## Response to Planning application from Hertfordshire County Council (T and CP GDP Order 2015)

District ref: 6/2022/2146/ADV  
HCC ref: WH/13866/2022  
HCC received: 20 September 2022  
Area manager: Matthew Armstrong  
Case officer: Steven Knight

H R OWEN MOSQUITO WAY HATFIELD AL10 9WN

Installation of signage to facade of east and west buildings together with site wide totem wayfinding signage

Drawn	Date	Checked	Scale @ A1
NER	AUG 2022		1:500
Job No	Drawing No	Revision	Note
2018-22	S-1000

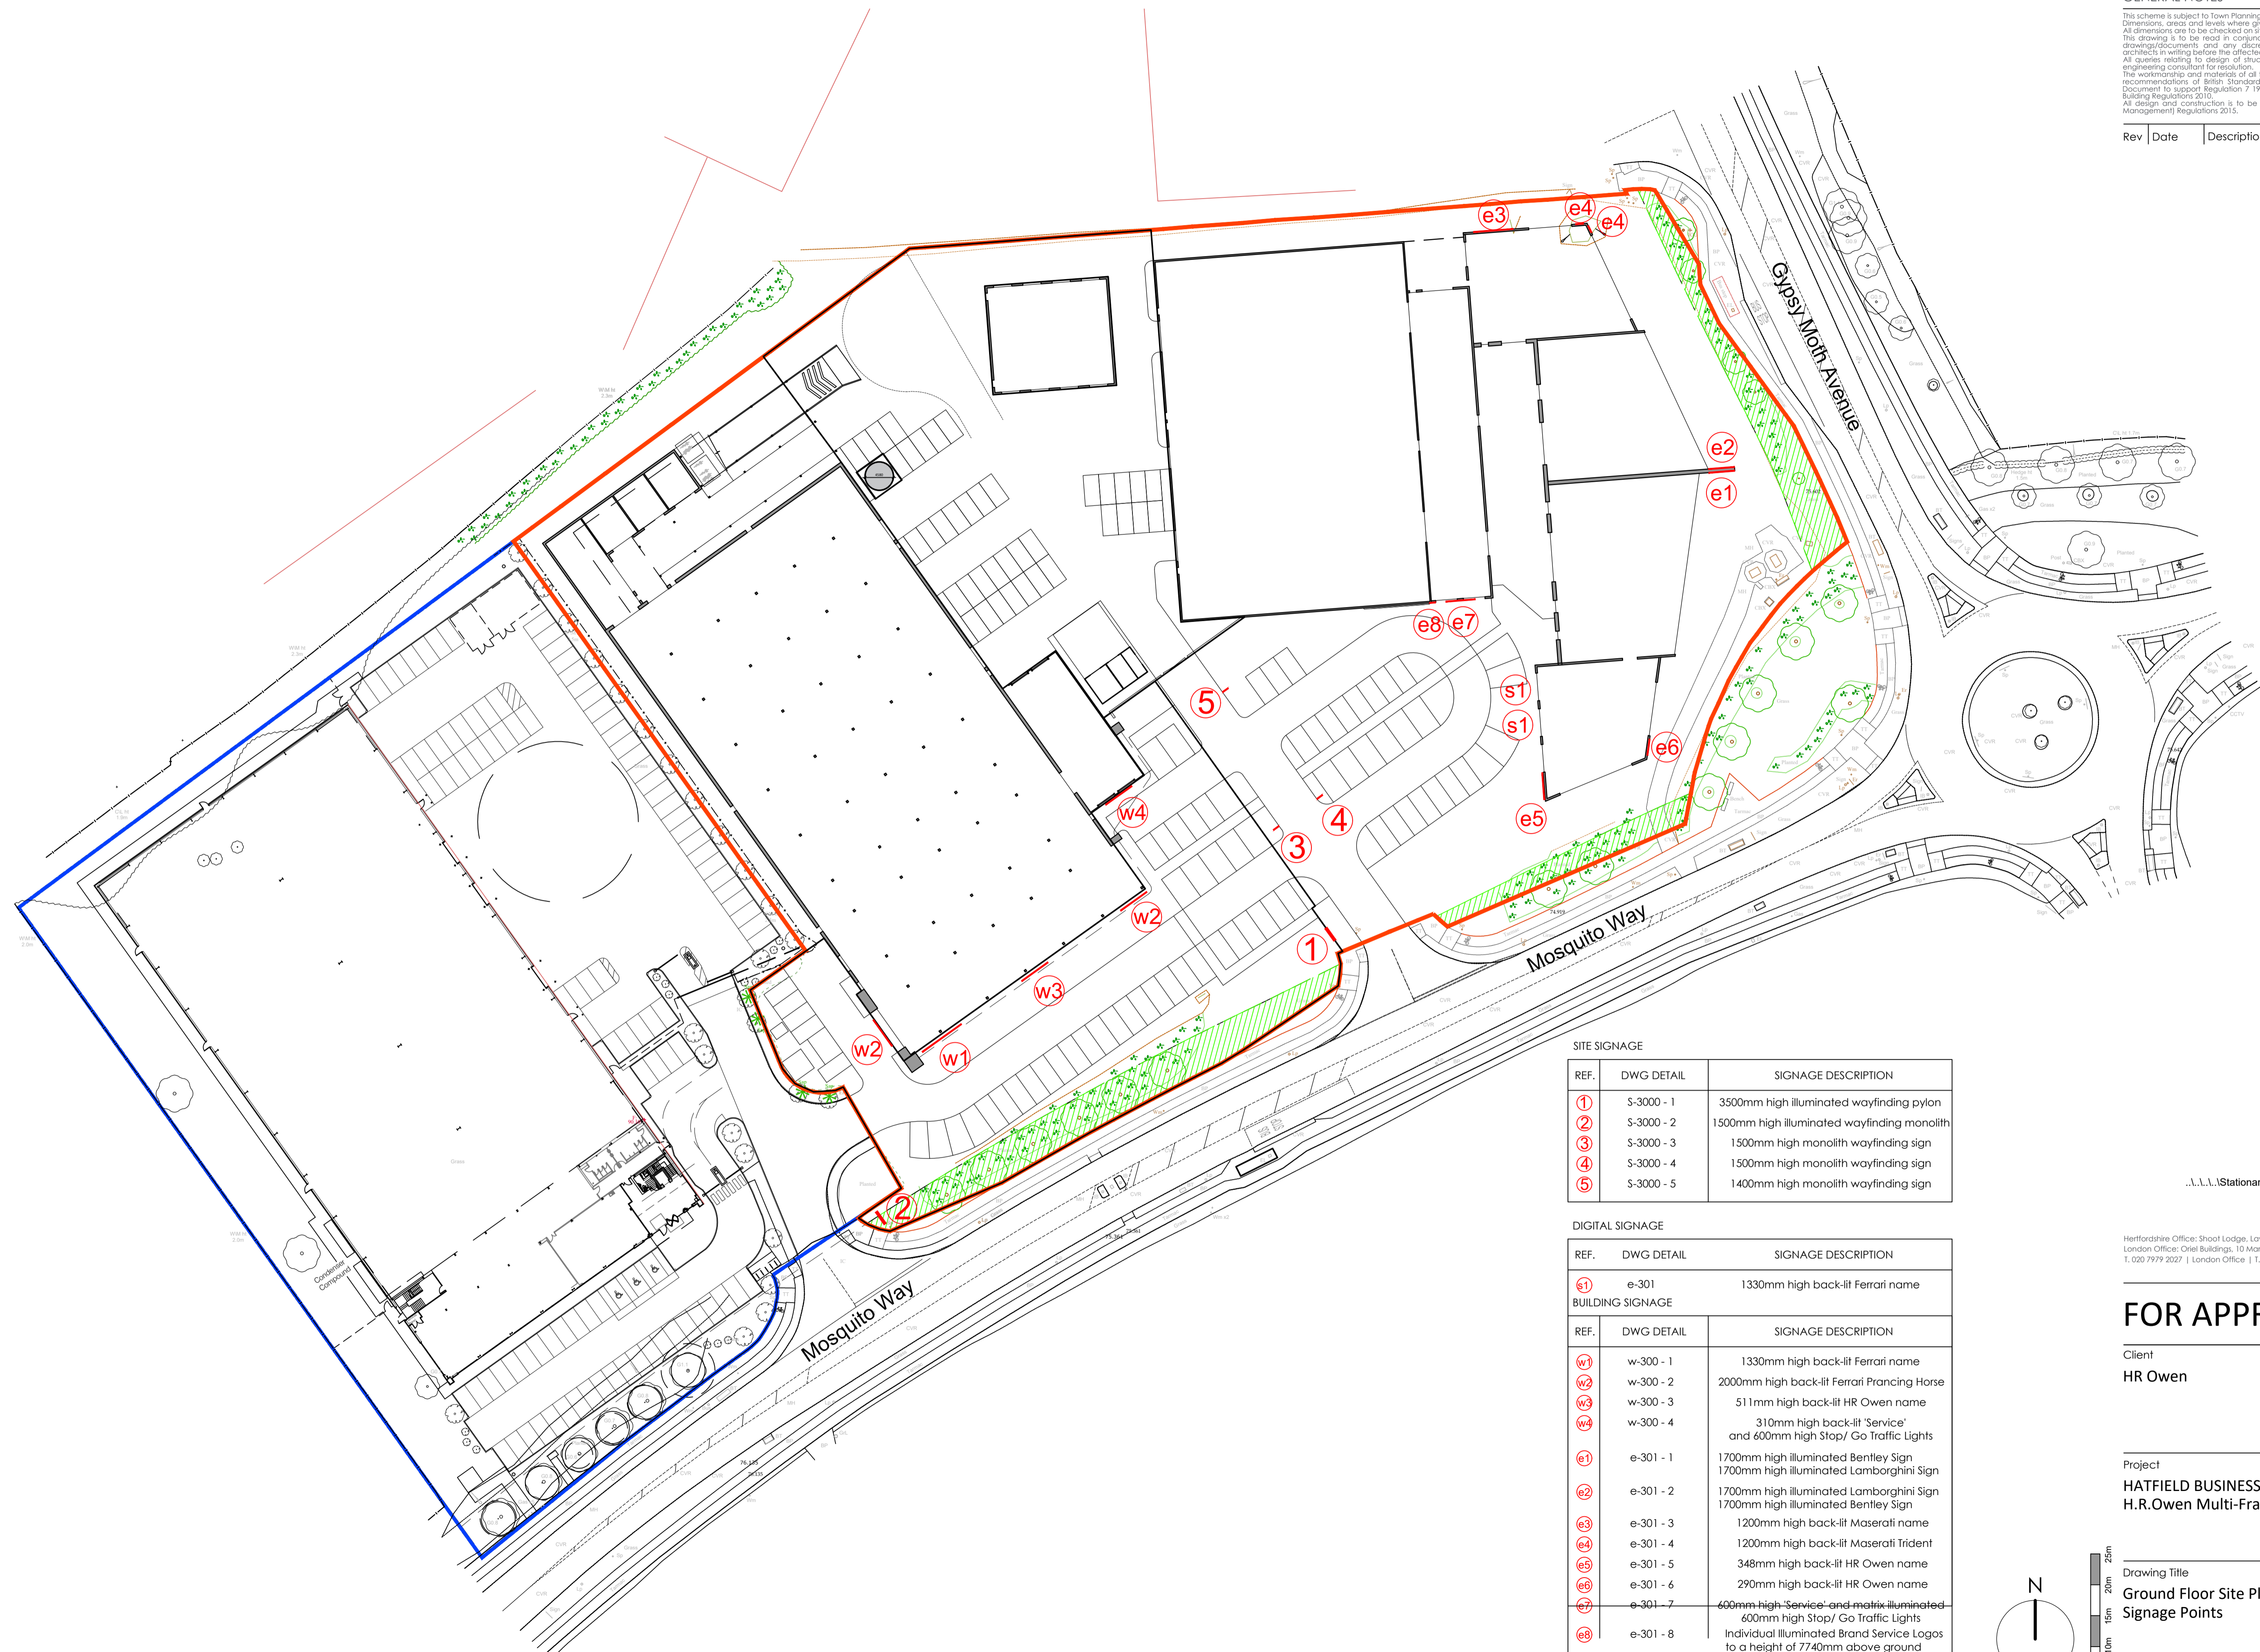
The wayfinding signs are of a simple design and are unlikely to distract from any other road signage. Signs 3 and 4 are relatively complicated with regards to the amount of information they contain but are far enough into the site that they will not impact on the highway. The applicant should ensure that the location of sign 2 is not part of the public highway.
